## **Thanet Extension Offshore Wind Farm**

Appendix 8 to Deadline 2 Submission: Applicant's  
Response to Kent County Council Local Impact  
Report

Date: February 2019

Temporary Stopping Up of
Public Right of Way -
Sheet 1 of 2

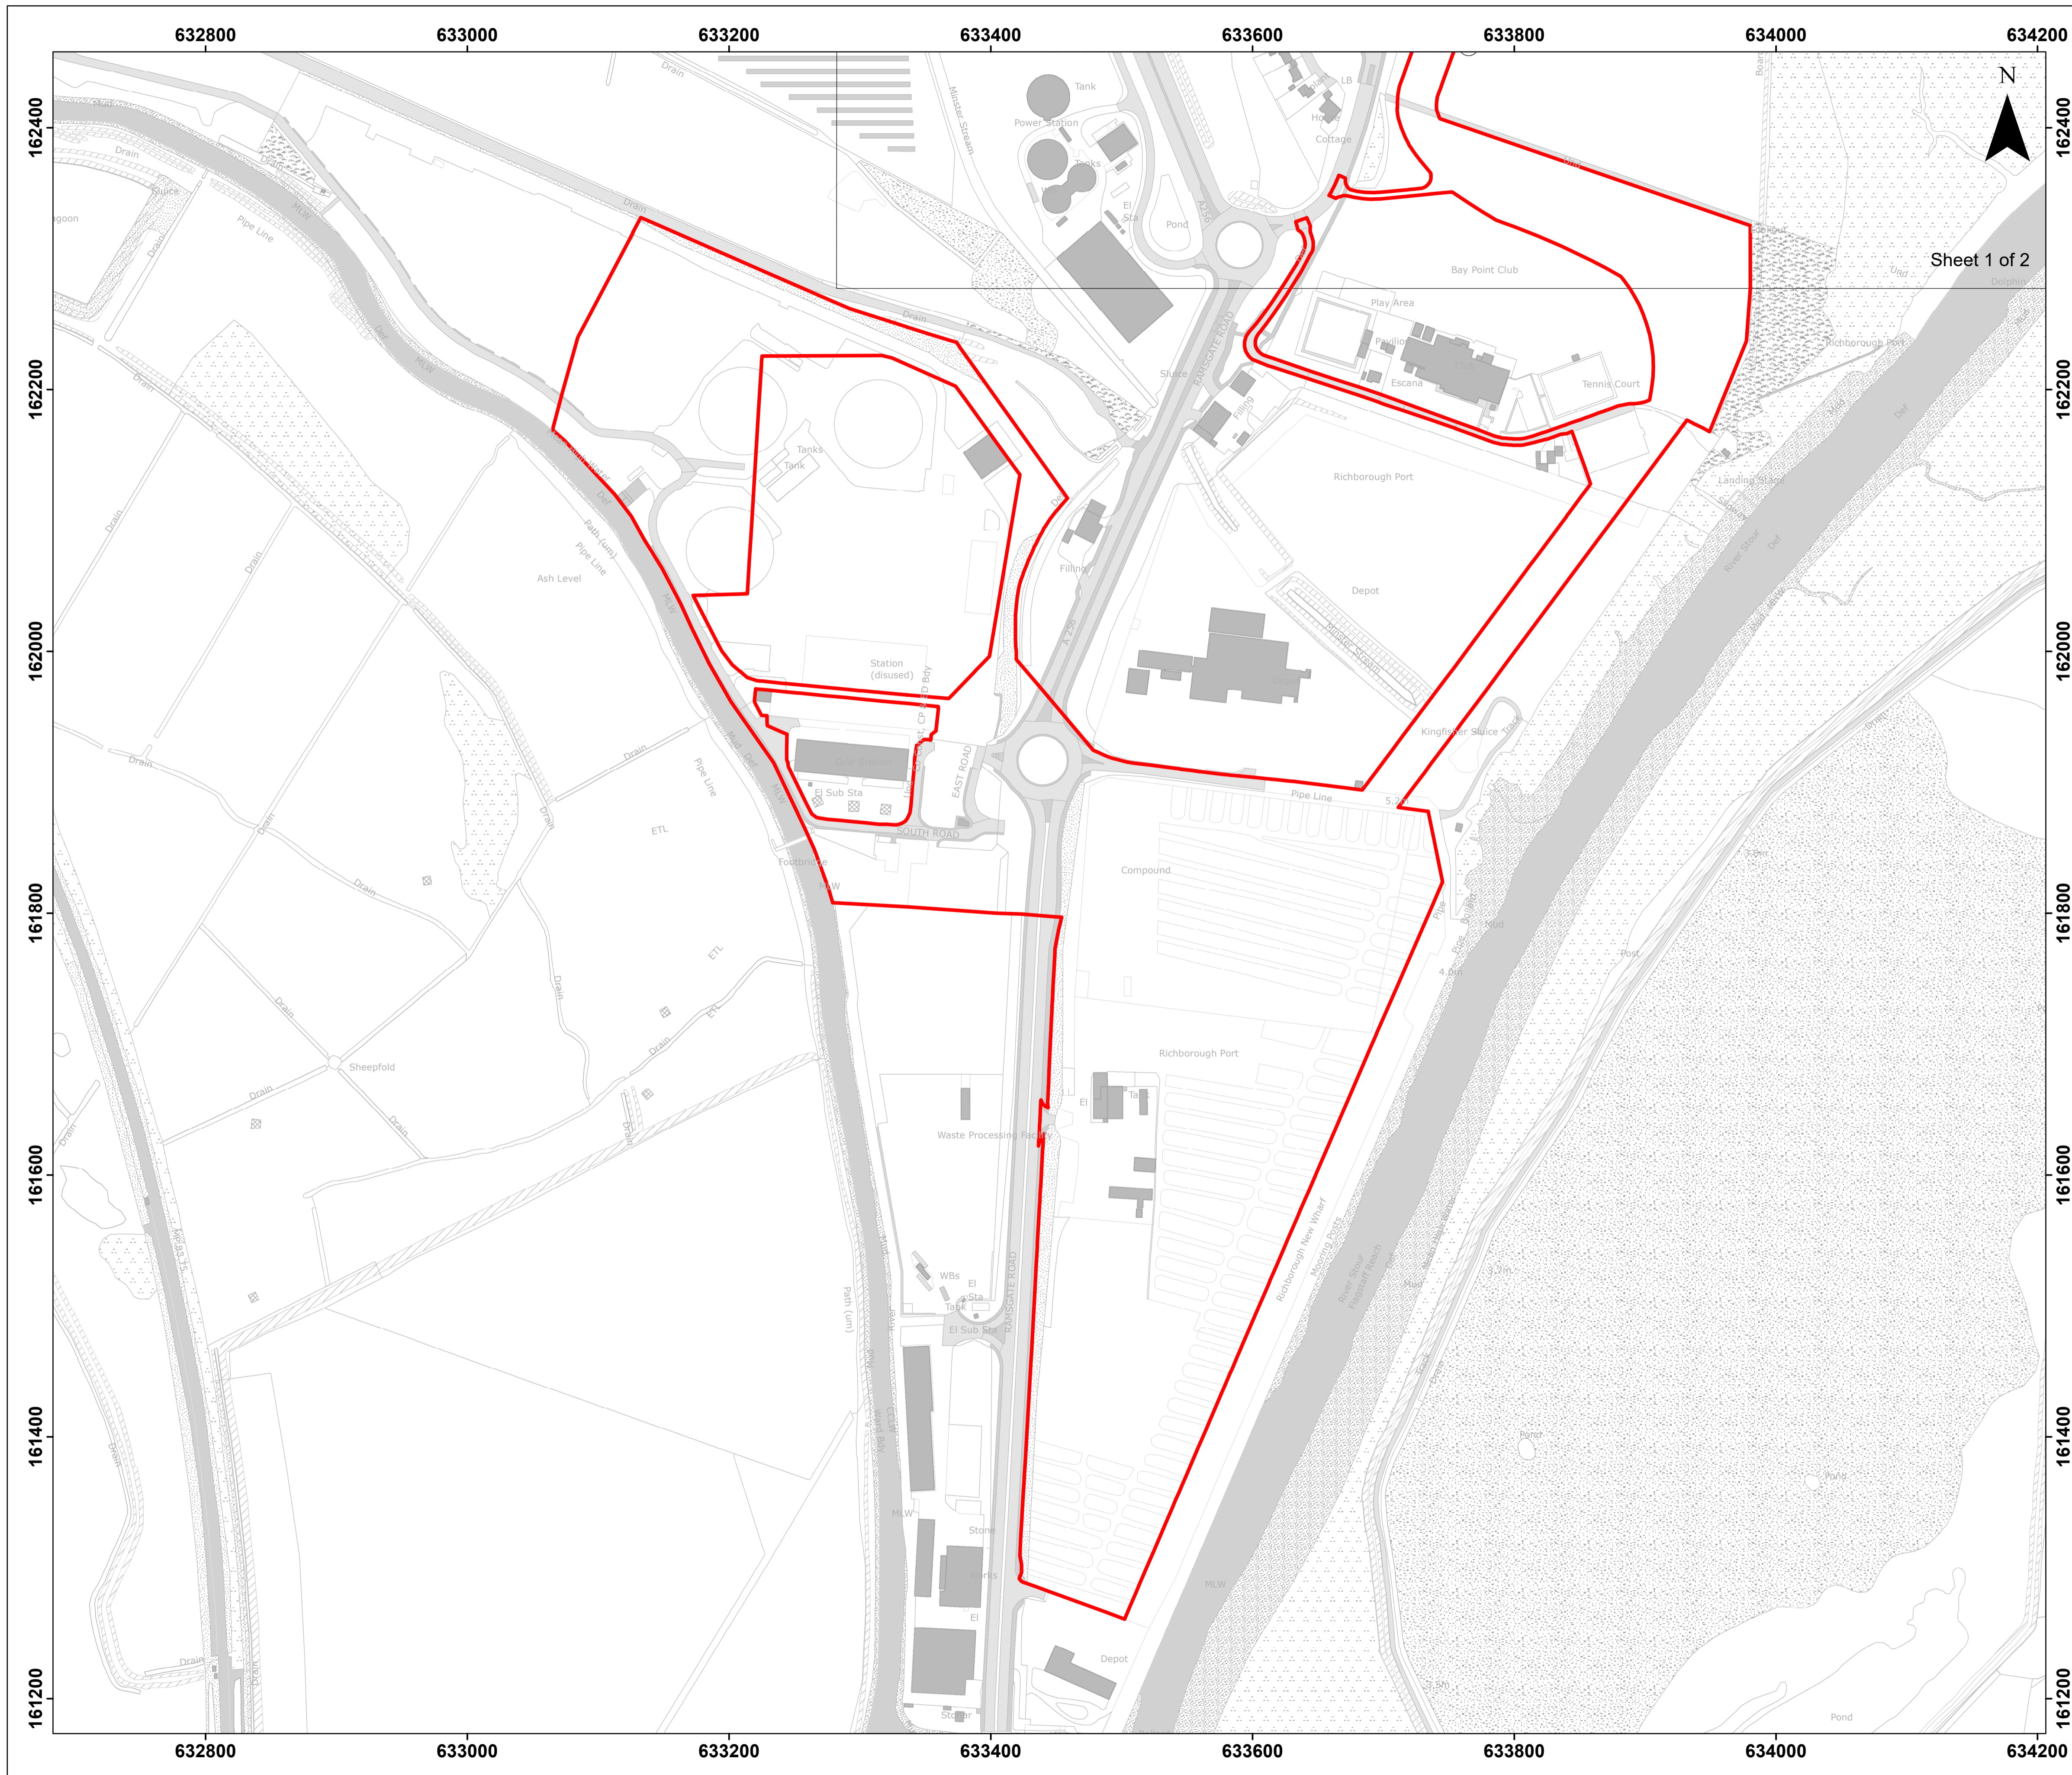
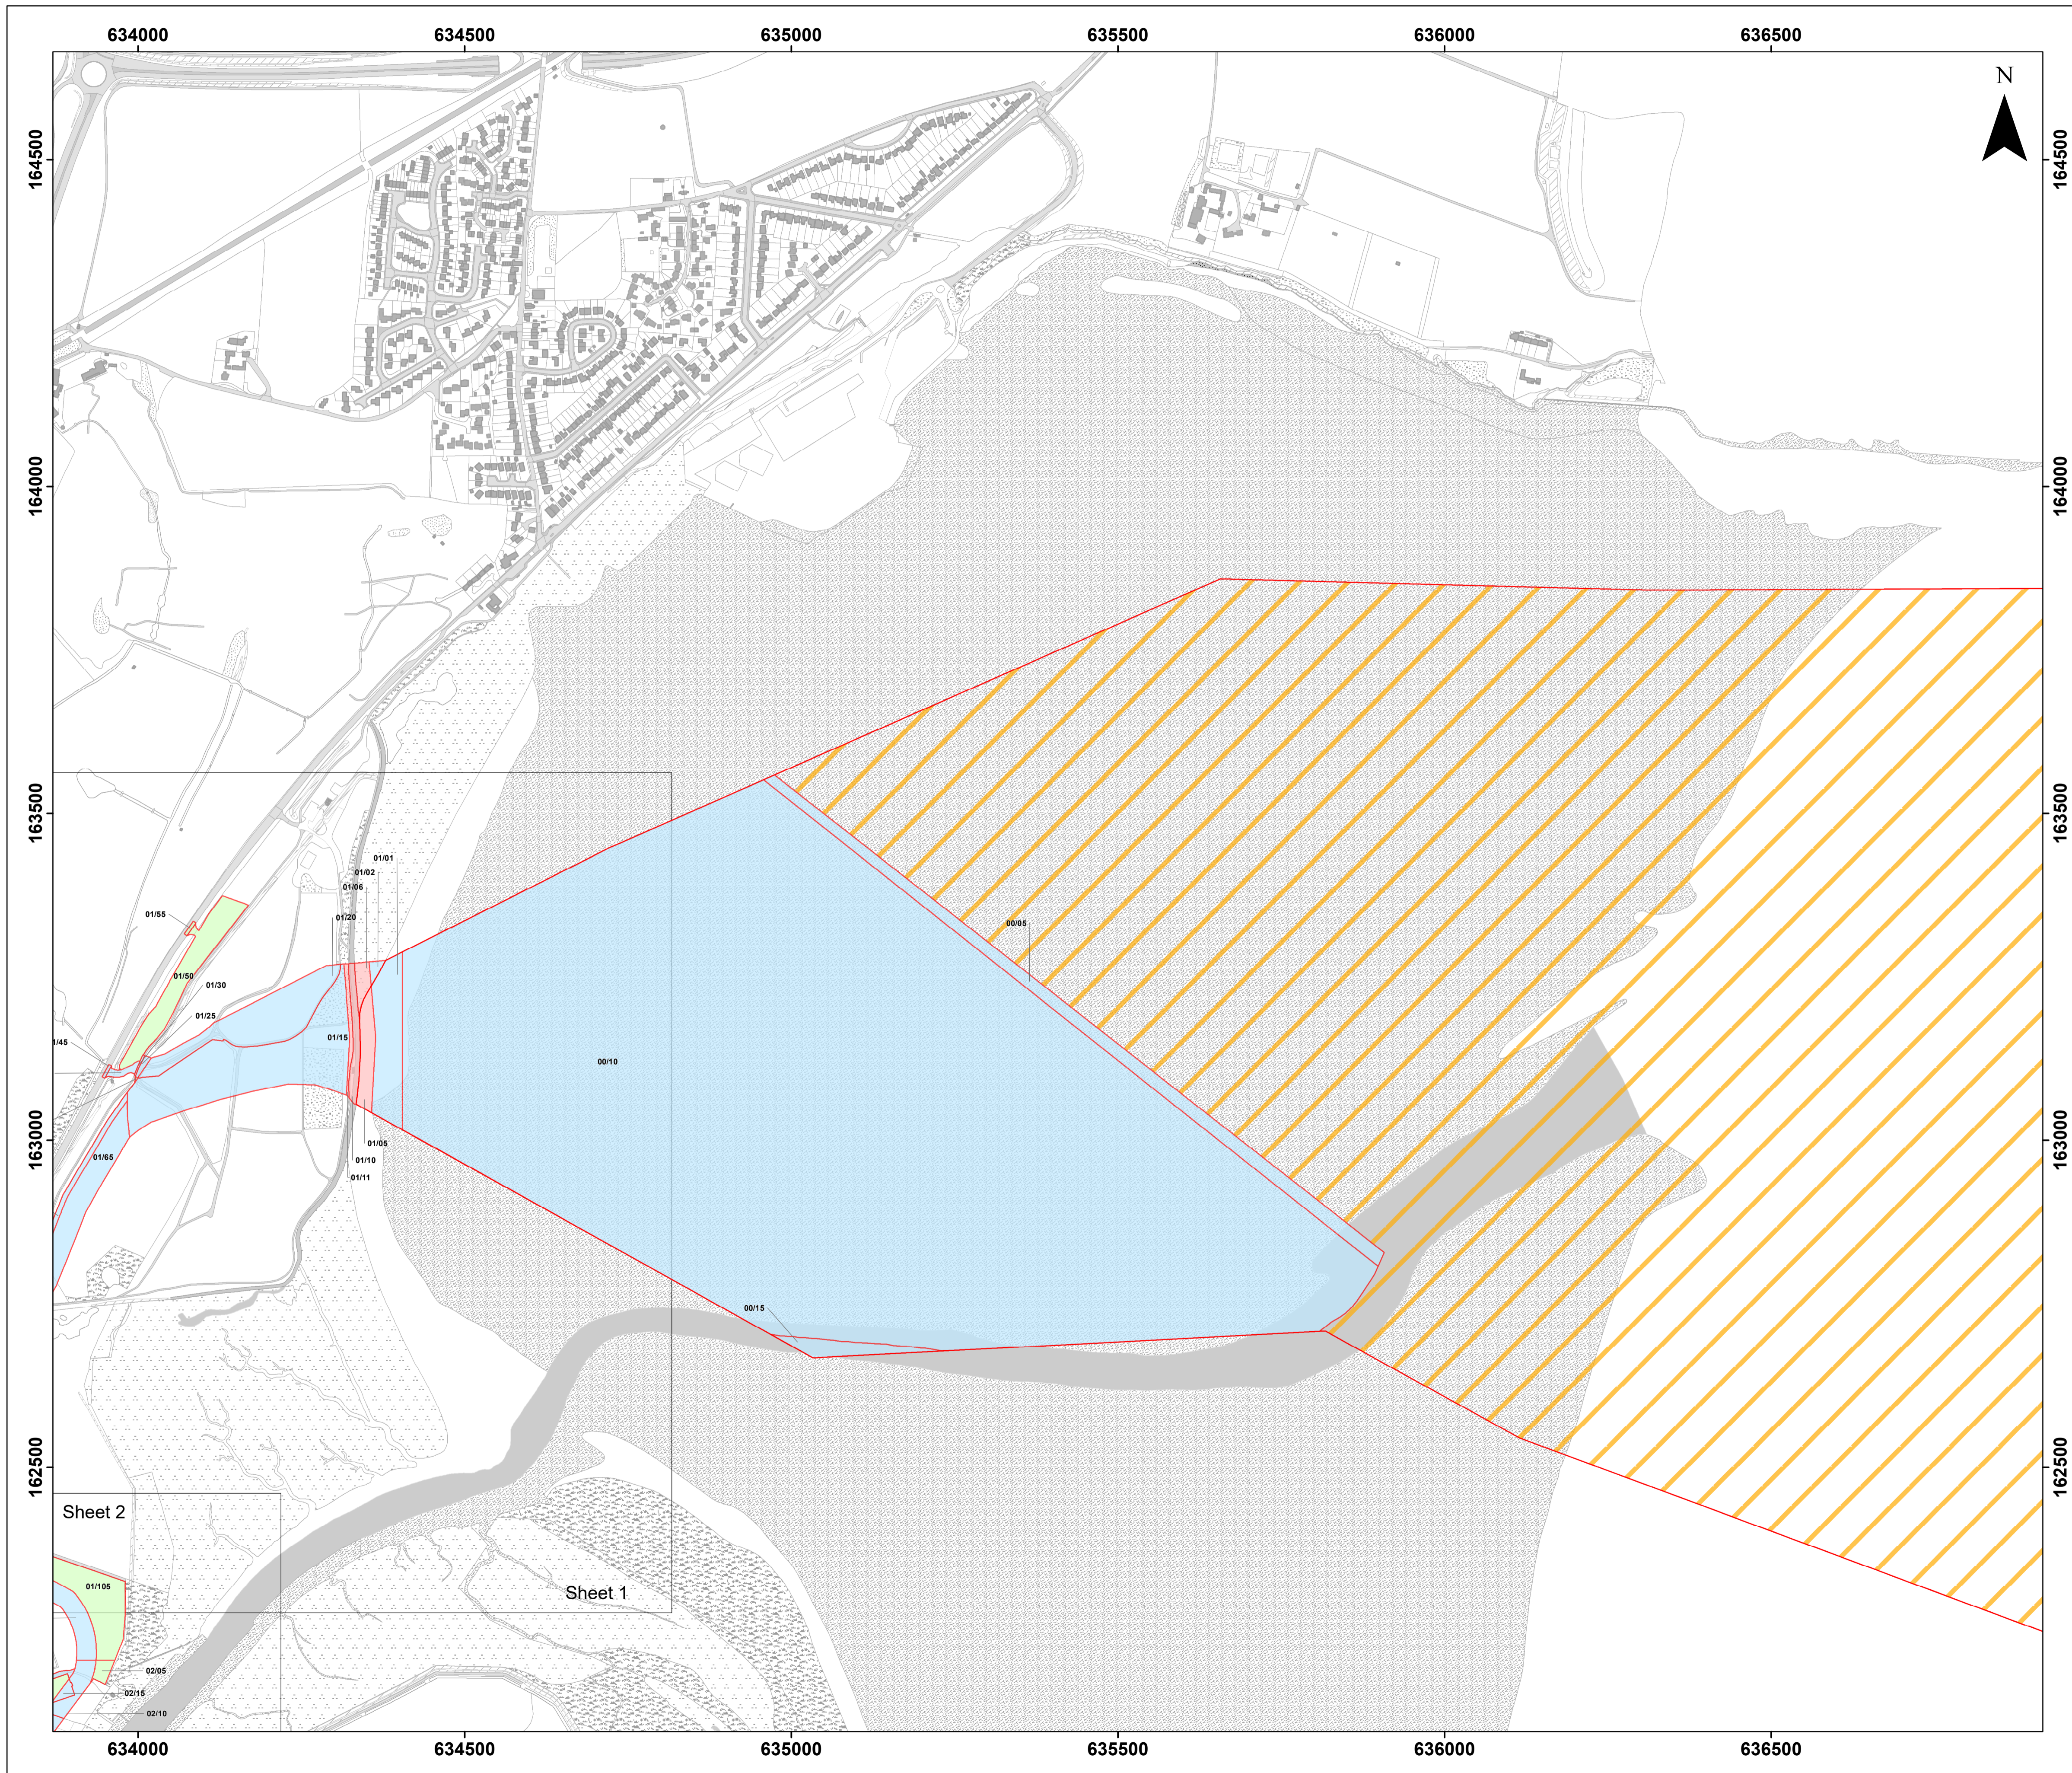
<p>Within Option 3 (open trenching), the England Coast Path (ECP) will be affected, if not temporarily closed, due to the planned works. The applicant should work closely with relevant KCC PRoW officer to ensure the path is adequately re-routed to allow access across the park whilst the works are undertaken. The OLEMP states that, ‘where possible soils will be carefully restored’ where the ECP is disturbed. This will need to be looked at in detail with KCC officers to agree the reinstatement of the soil and a method of colonisation of vegetation.</p>	<p>This is noted and agreed by the Applicant, as stated in the OLEMP (PINS Ref APP-142/ Application Ref 8.7).</p>
<p>The application will need to apply for a temporary Traffic Regulation Order (TRO) whilst the work is undertaken. The team in KCC will need a six-week notice period to process the TRO for the project.</p>	<p>This is noted by the Applicant, all TROs or other relevant applications will be made according to the specified timescales and requirements of the DCO.</p>
